Our Ref: EP/88/08/

3rd July 2008

The Town and Country Planning Act 1990 (as amended)

Change of use from Bank to Indian Tandoori Restaurant (A3)
27 Sea Road East Preston

Proposed Front Elevation

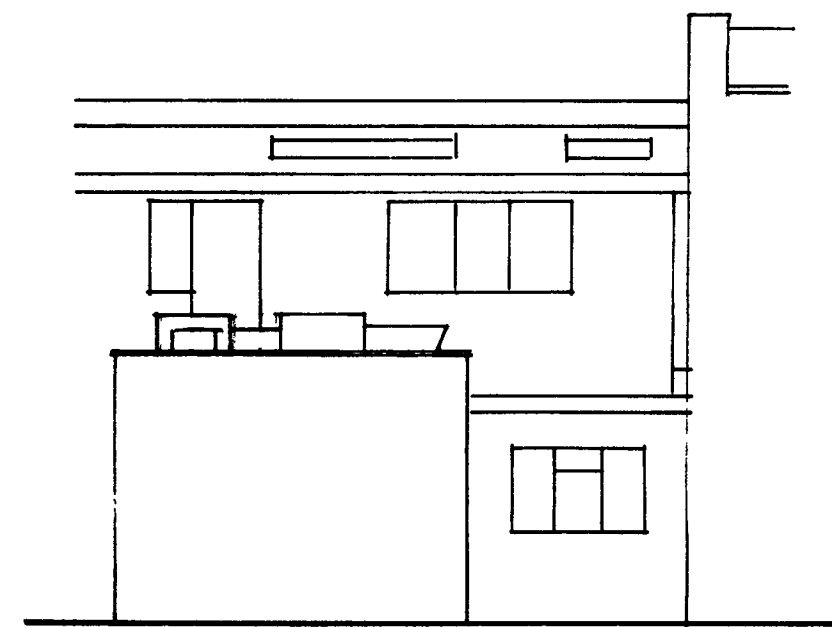
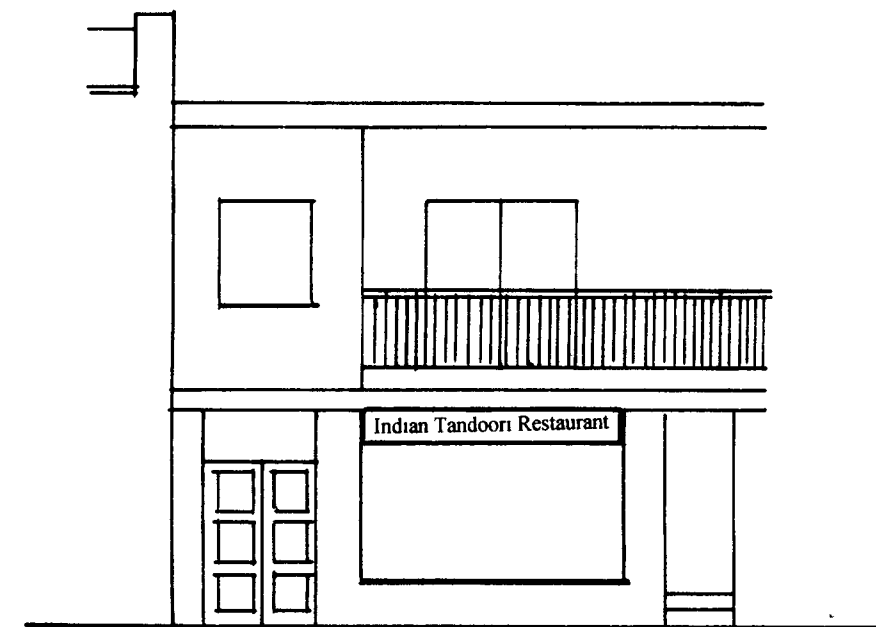
Page 15 of the East Preston Village Design Statement states that 'Shopfronts: should be designed to harmonise with the neighbouring styles and colours. Major changes in style of individual units should be avoided.' The Parish Council is keen to see that this is enforced. □

Proposed Ground Floor Plan

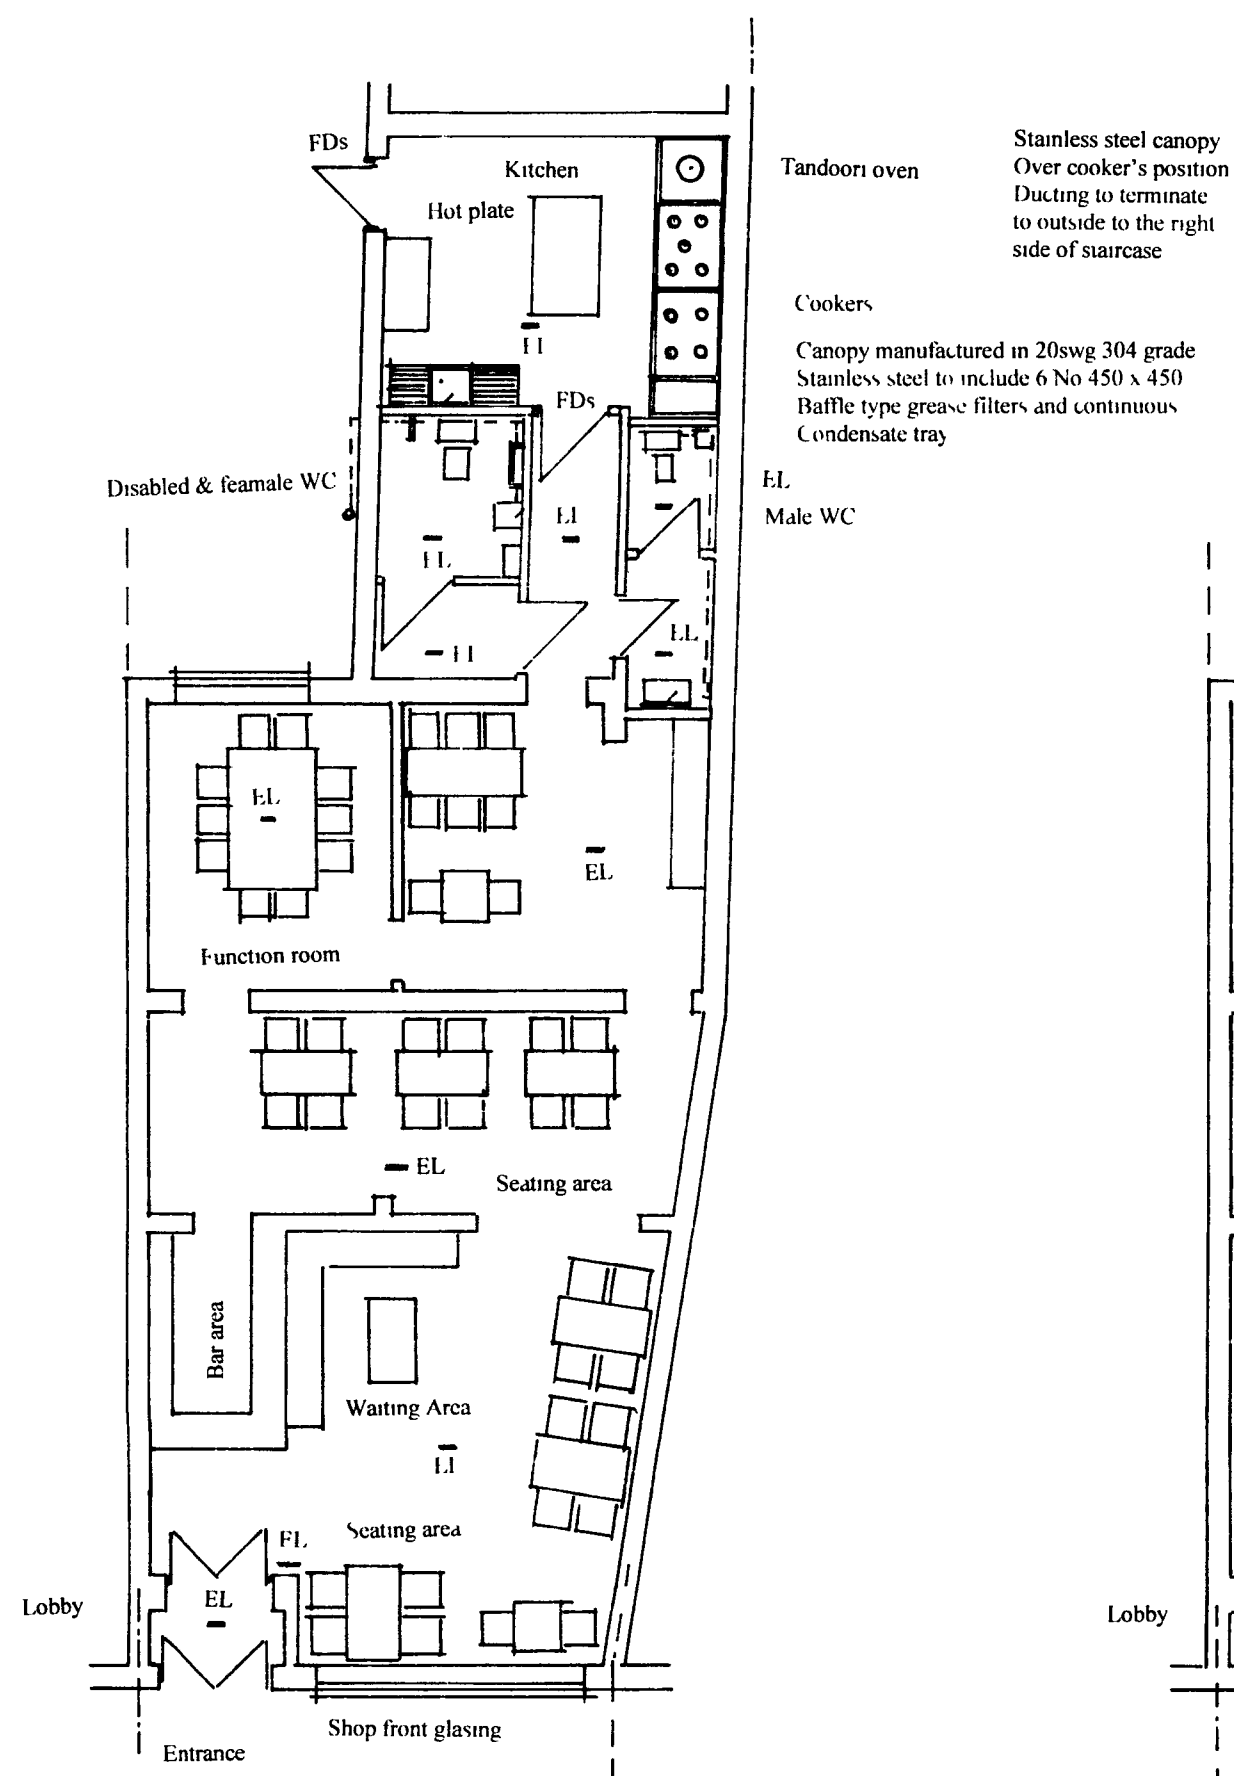
The Parish Council is concerned that the District Council does everything necessary to ensure that ventilation is as good as it possibly can be, and that the ventilation itself does not cause nuisance to neighbouring businesses and householders. There are residents directly above the proposed business and new houses have just been built immediately behind. □
